## **WEST MIDLANDS INTERCHANGE – WRITTEN REPRESENTATION FOR DEADLINE 2 SUBMISSION**

As an interested party to the examination of the West Midlands Interchange DCO Highways England make the following Written Representation.

M6 Junction 12 and Calf Heath Reservoir

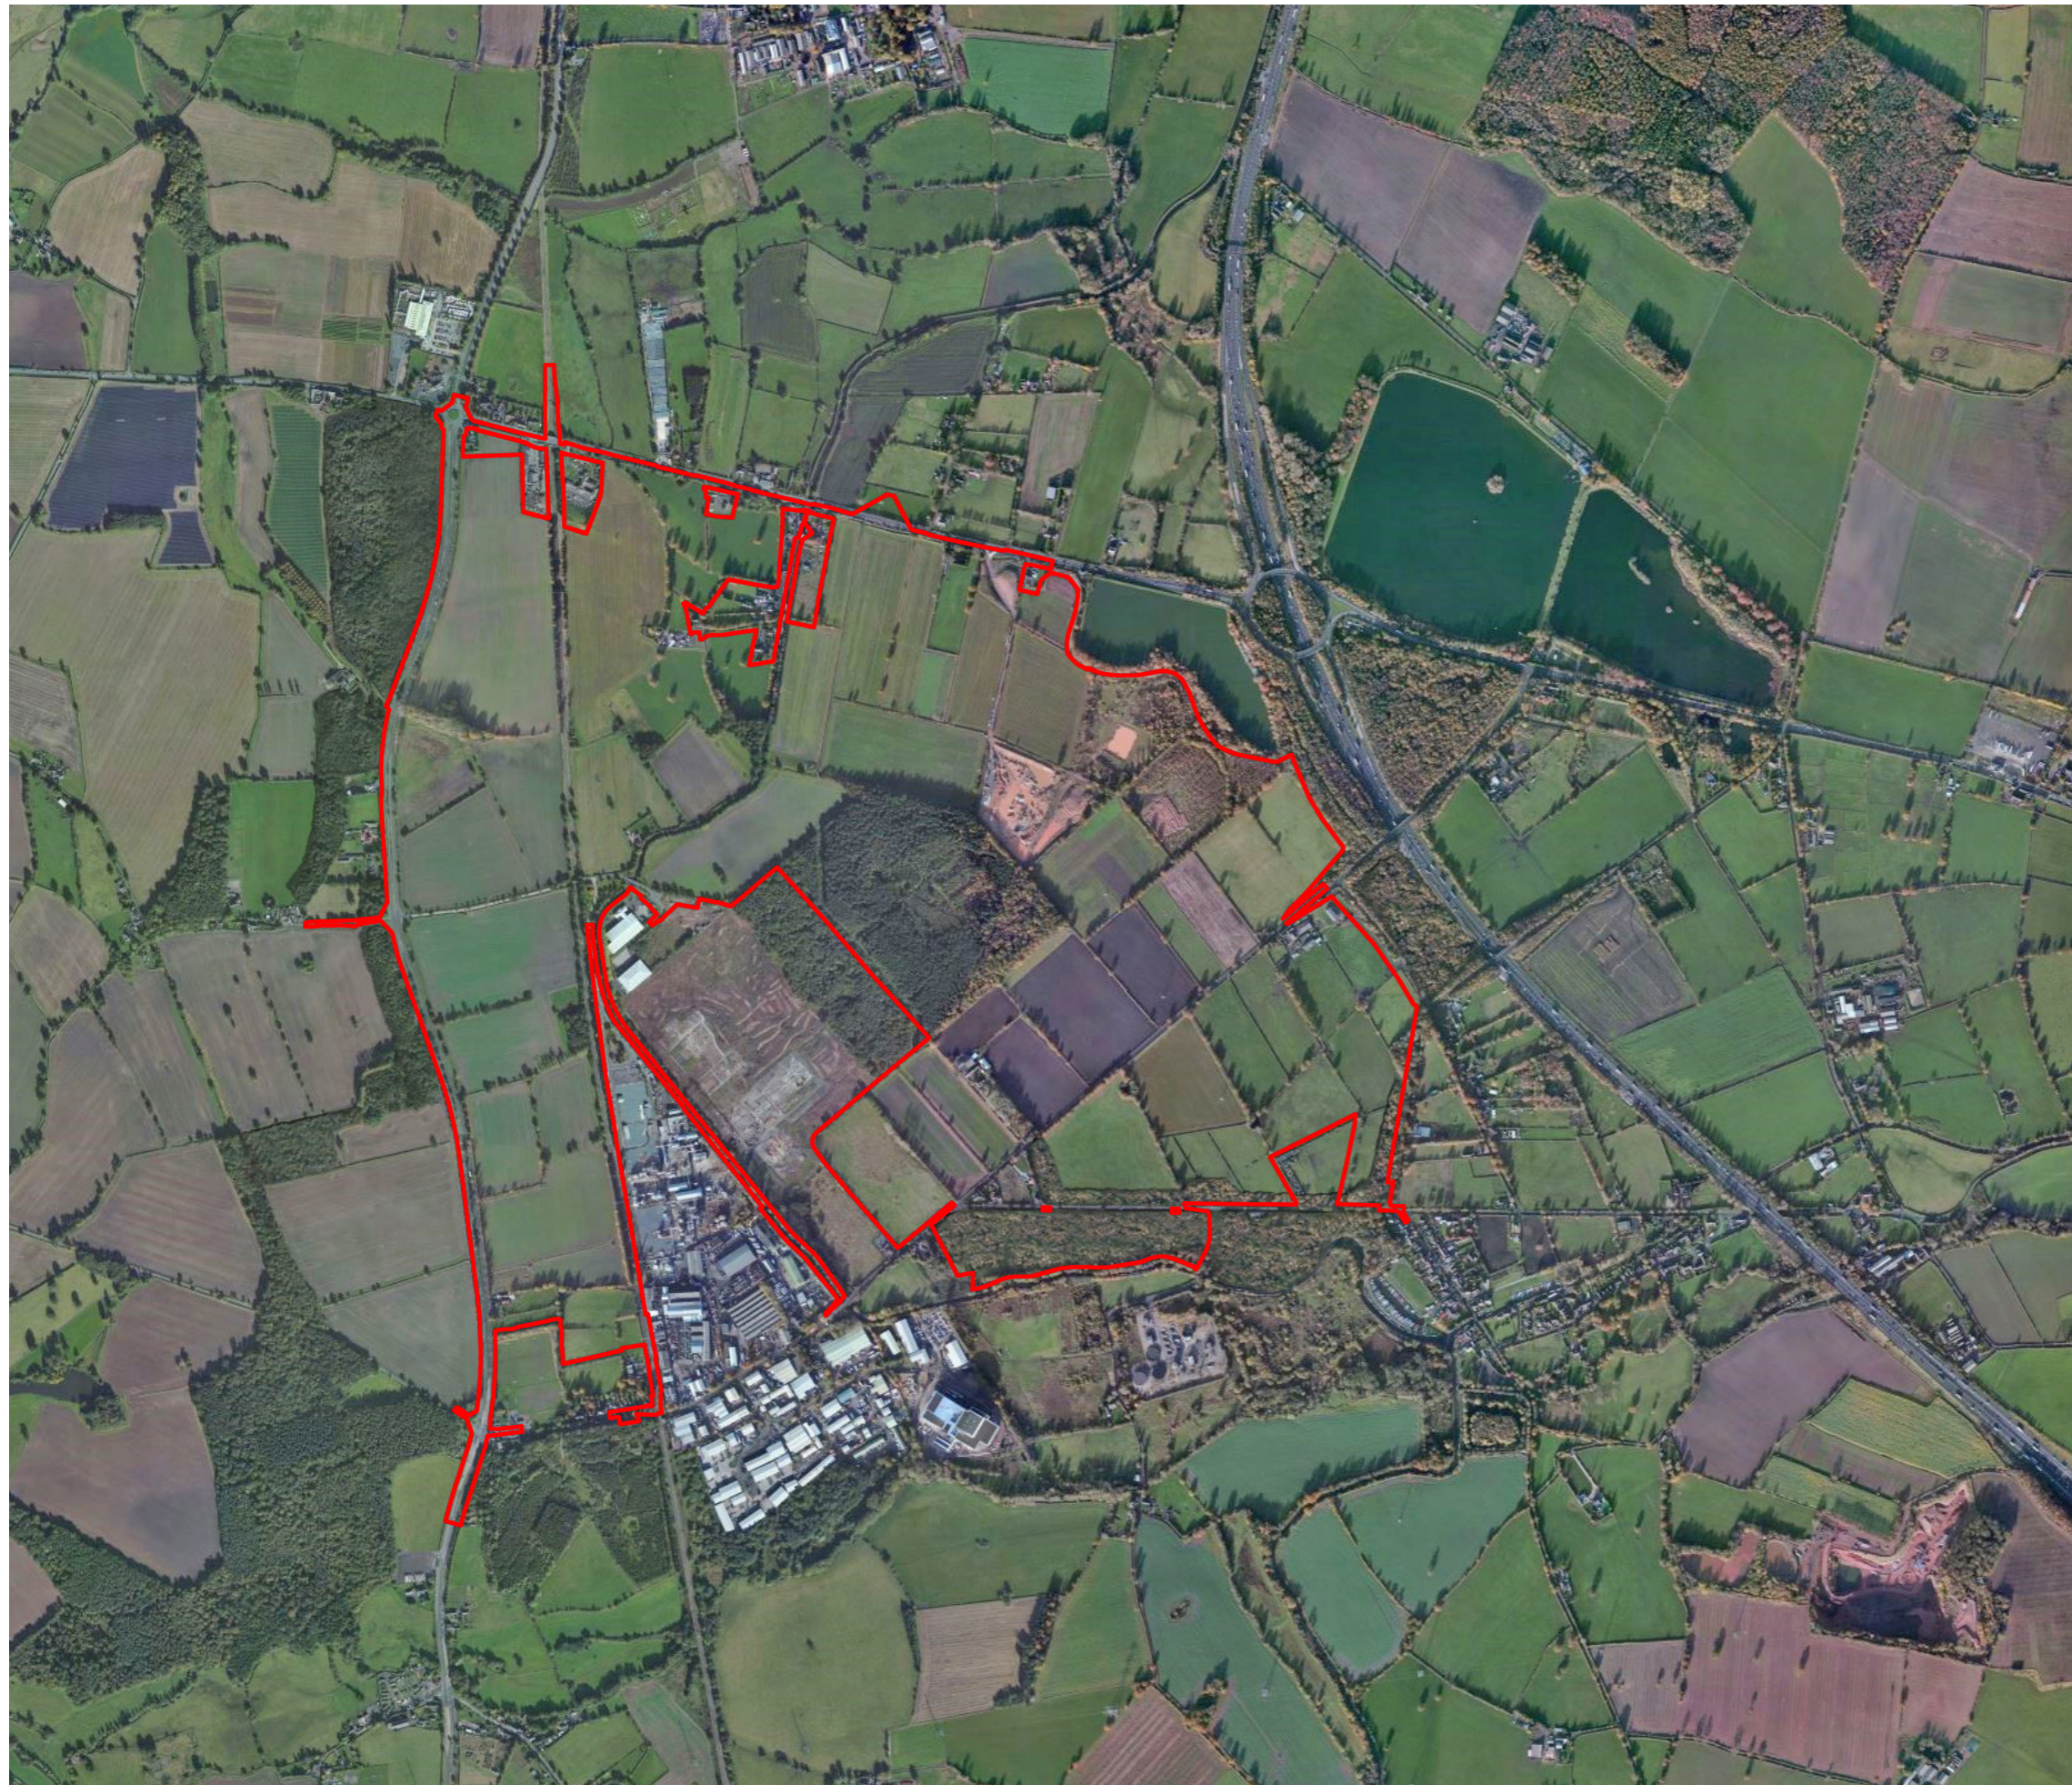
At this stage we raise particular concern with the findings of the RSA 1 in respect of M6 junction 12. Although capacity assessment of the roundabout in scenarios with development traffic is satisfactory, the RSA 1 has identified safety concerns that may escalate with development traffic. Potential options for addressing this concern may involve works at the junction but outside the DCO boundary which the applicant will not have the power to undertake. We note that the applicant is reviewing our observations and we expect further information being supplied in due course.
